PLAN EXAMINATION RFI HOLD

PROJECT/SITE DESCRIPTION:
Maine Medical – Visitor’s Garage Extension

PROJECT ADDRESS:
22 Bramhall St – Portland, Maine

Review Type: All Trades
Plans Date: 3/9/18
of Sheets: 96
Project Area (sq. ft.): 82,201

2 METAL PANEL (P1) - PLAN DETAIL
1" = 1'-0"

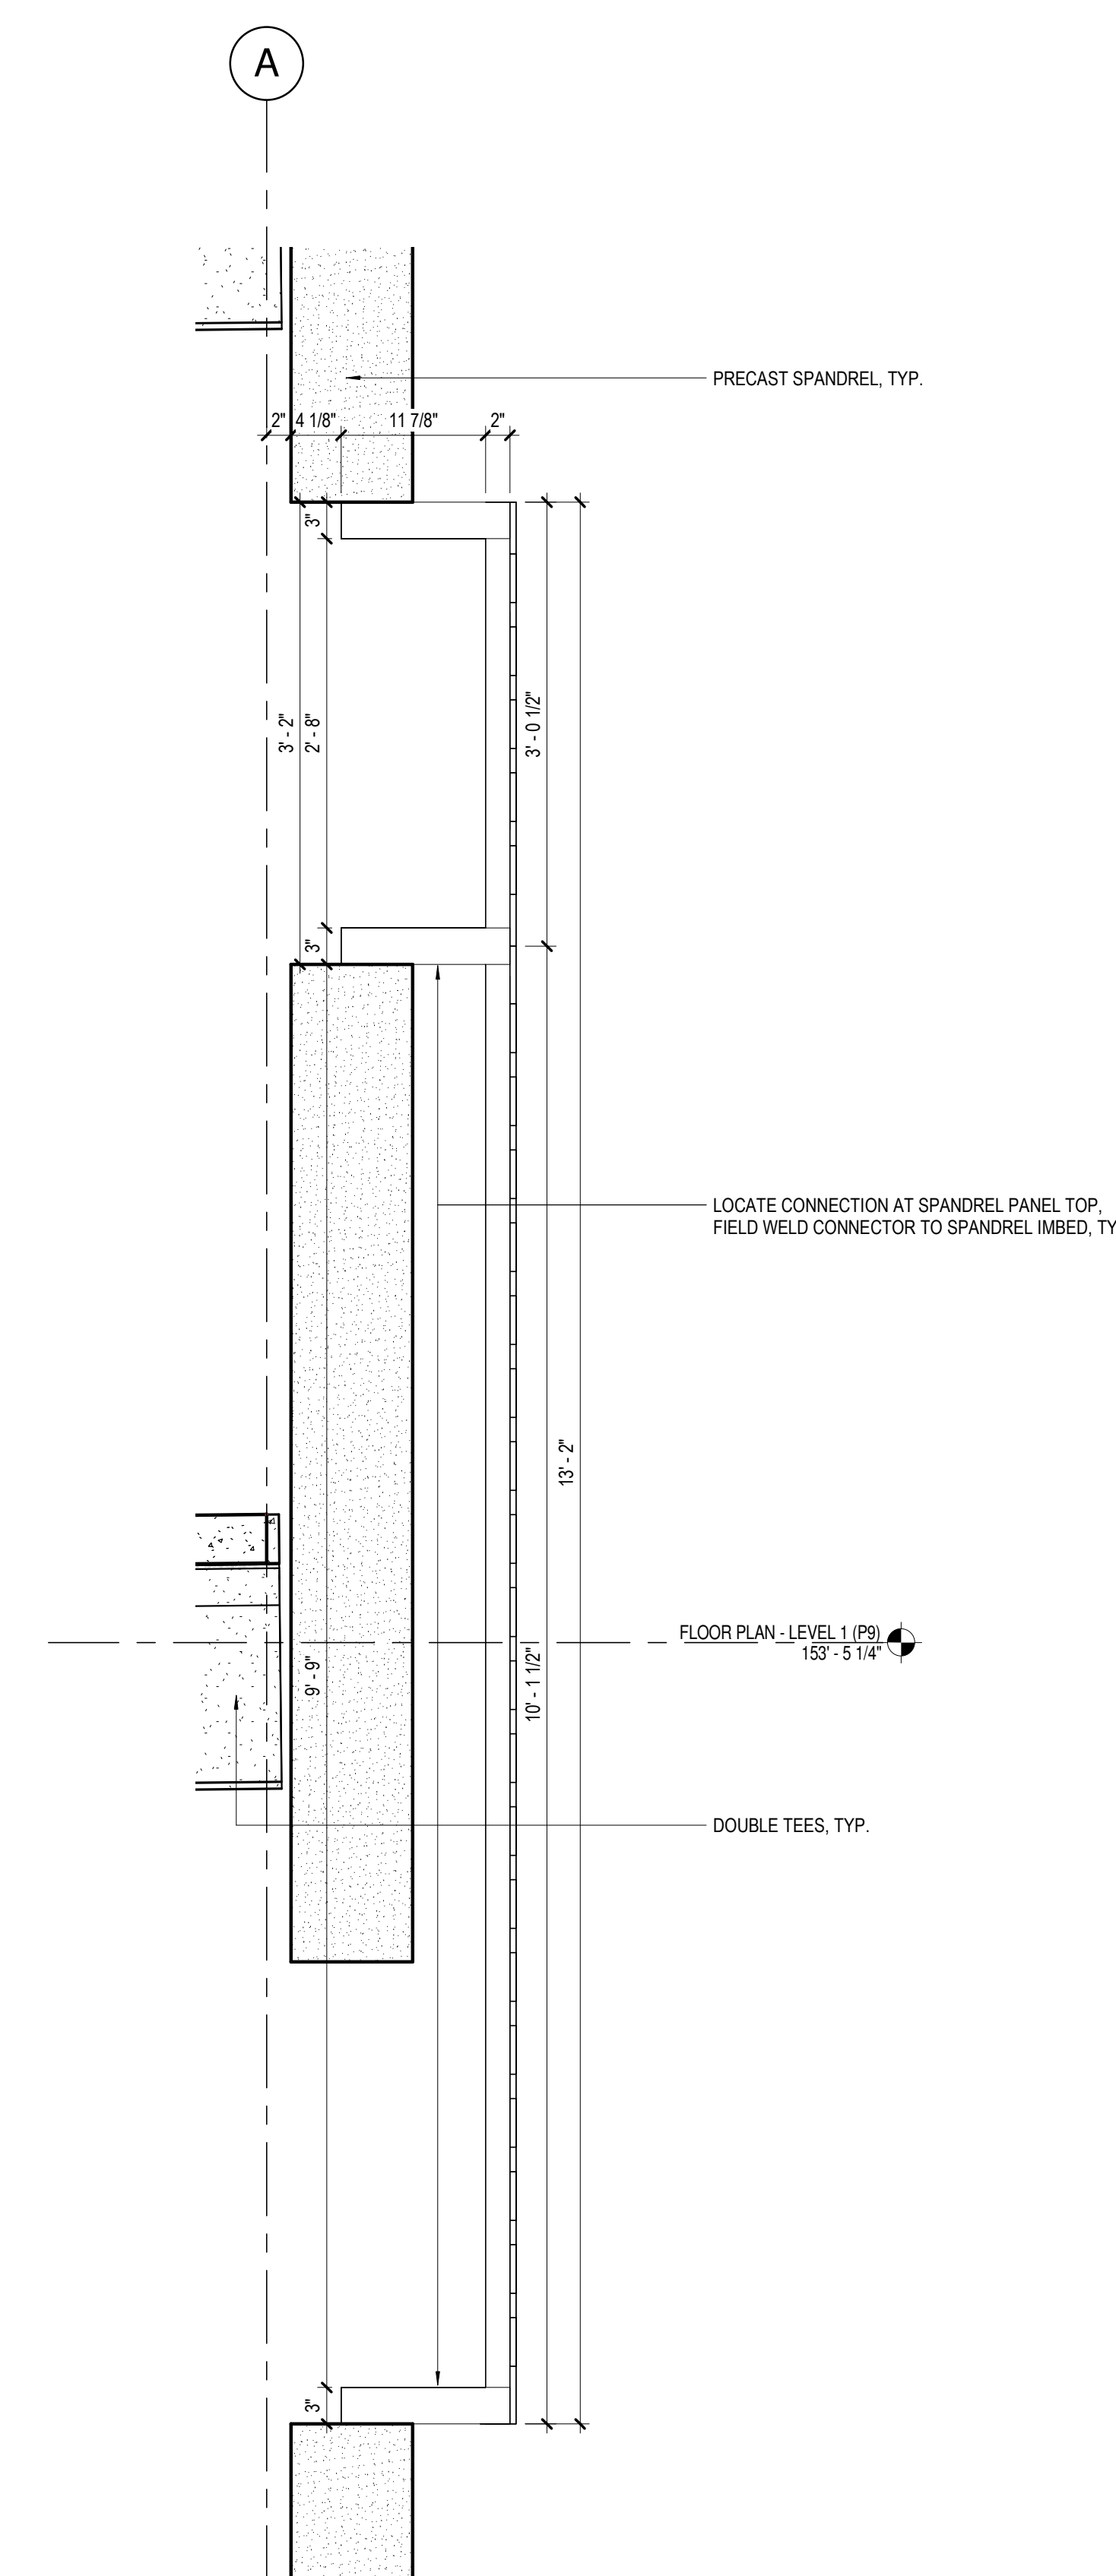
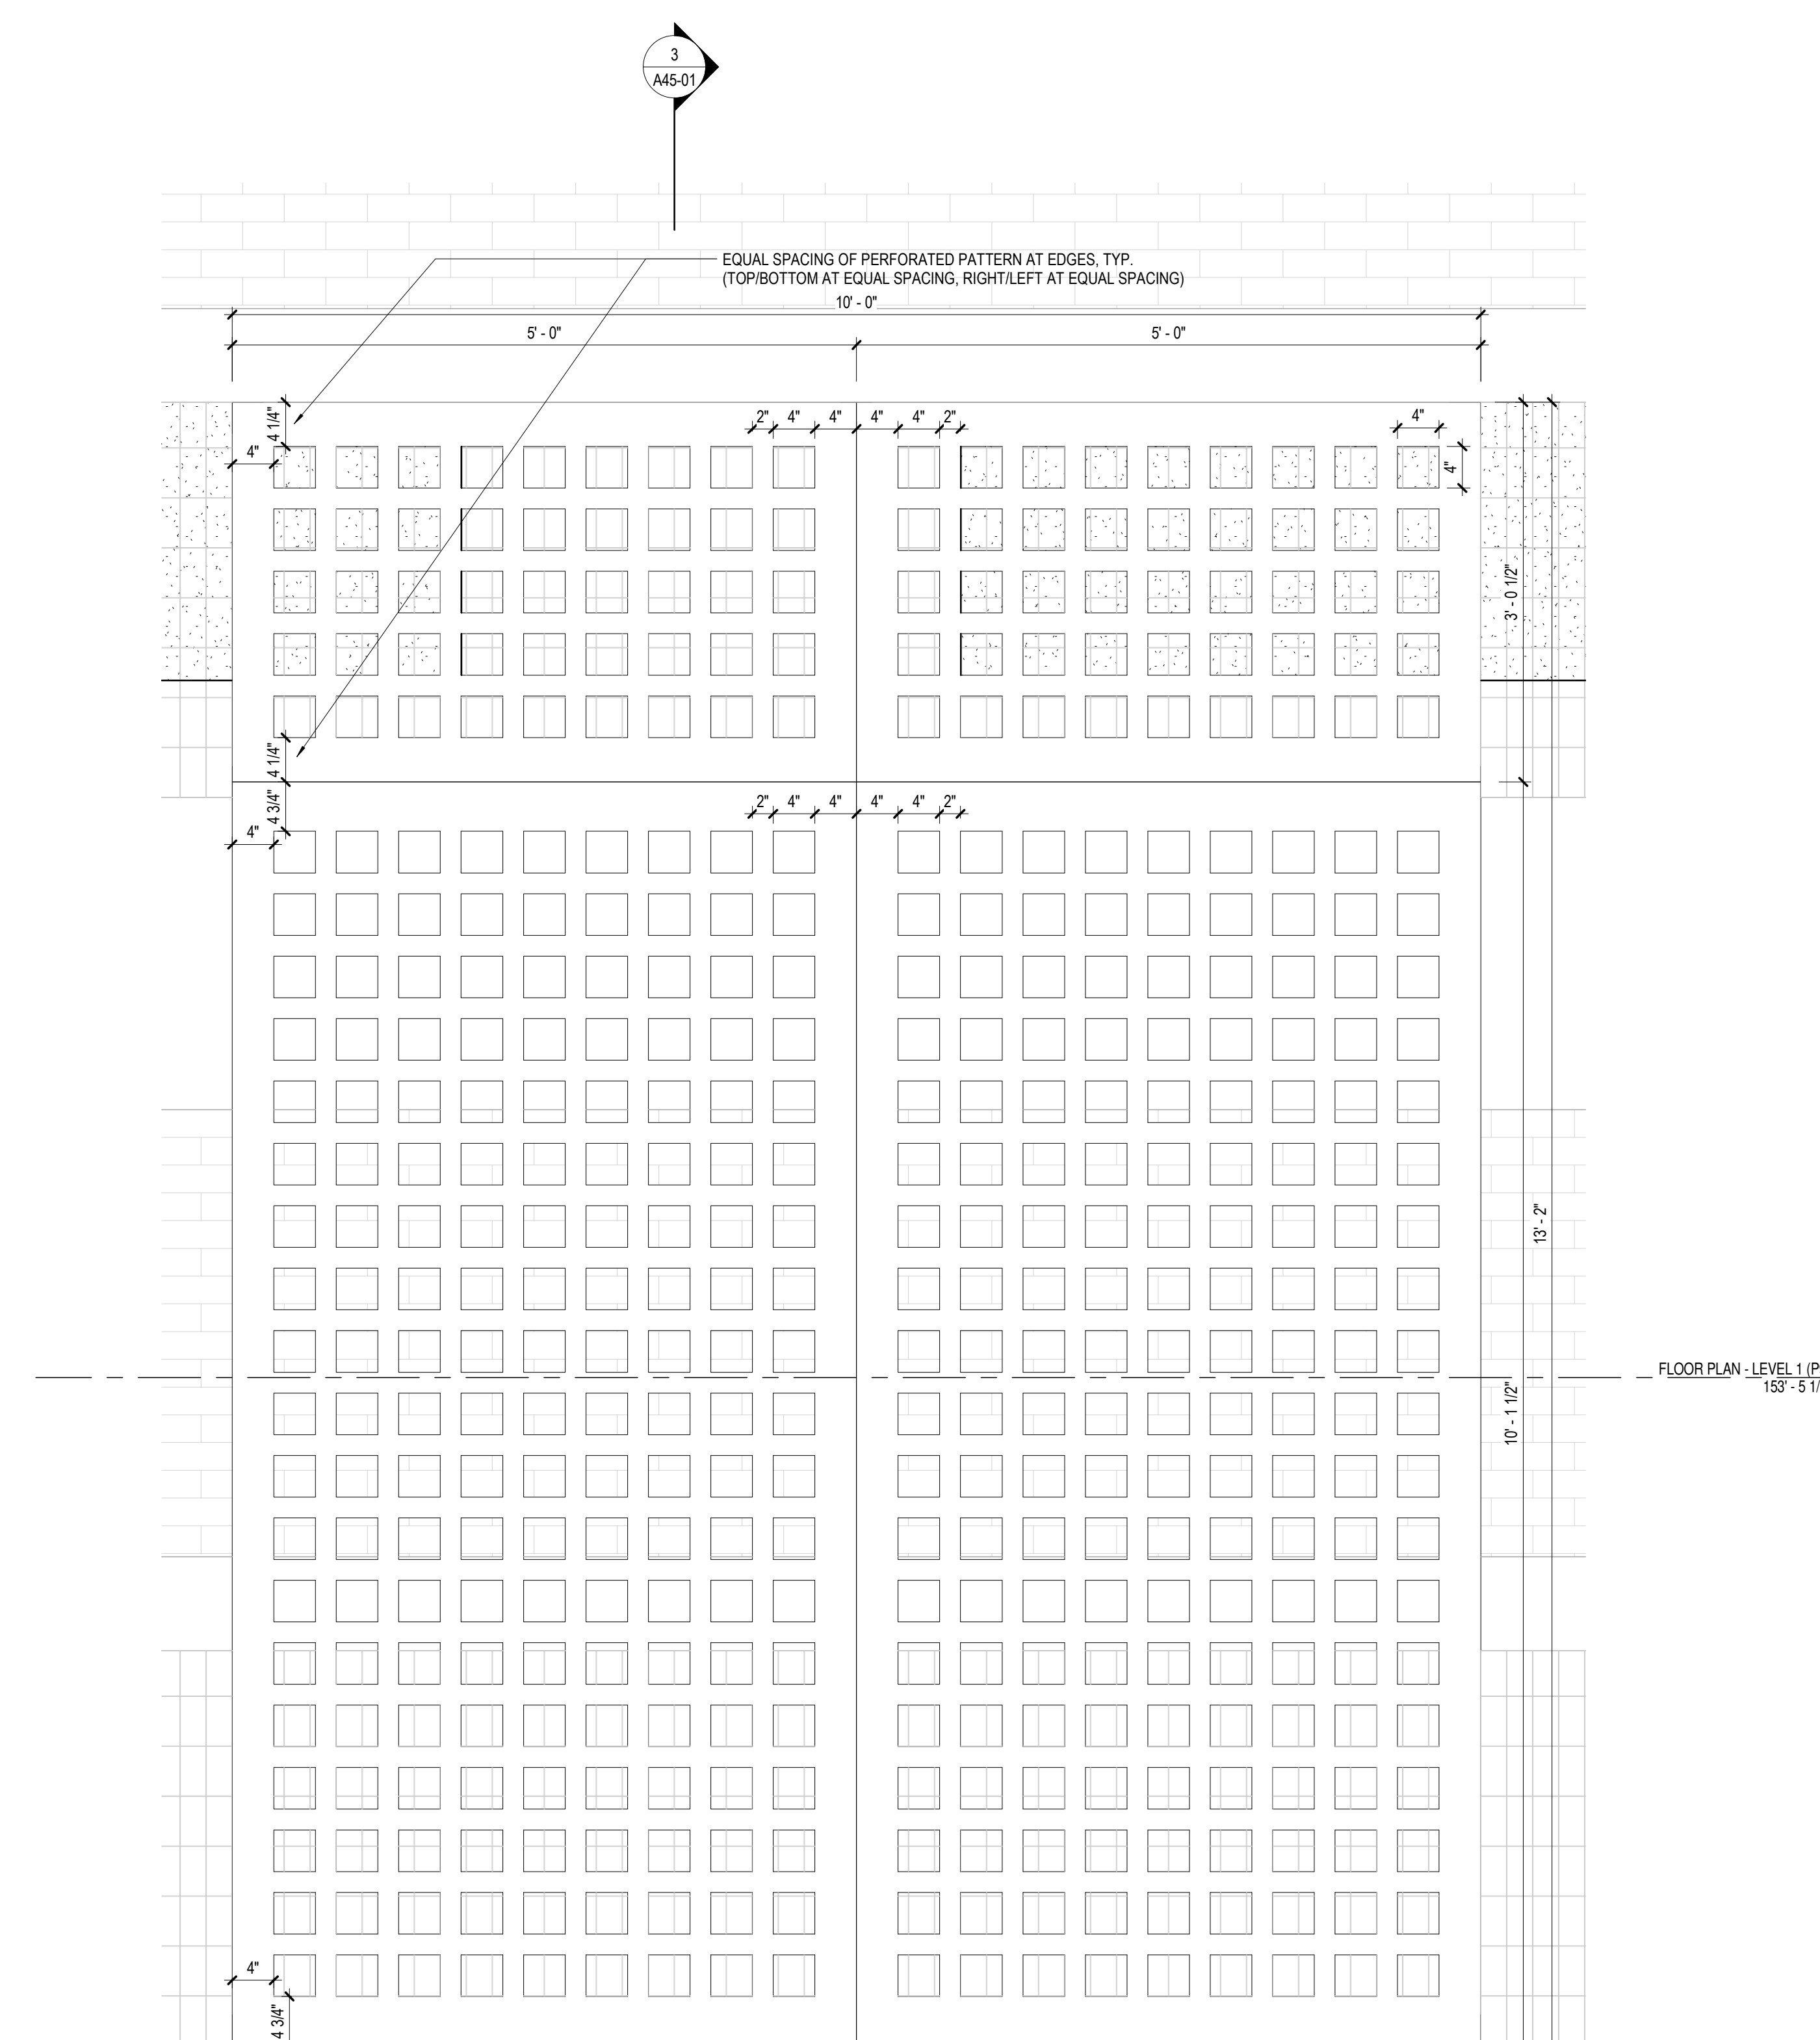
1. Architectural drawings for the decorative metal panel system, metal railing system, and fall protection fencing system (sheets A45-01 through A45-10) do not provide specific details for steel embeds or welds required for proper attachment to the precast concrete structure. Sheet A45-01 calls for the decorative metal panels to be field welded. Neither the structural drawings nor the precast panel shop drawings address these embed or welding details either. Per IBC sections 1405.11 through 1405.11.4, metal veneers on exterior walls shall be fabricated from approved corrosion resistant materials or shall be protected as described therein, attached by corrosion-resistant fasteners or other approved means, protected from the weather, and grounded as required by IBC chapter 27. Please provide additional information and revise as required.
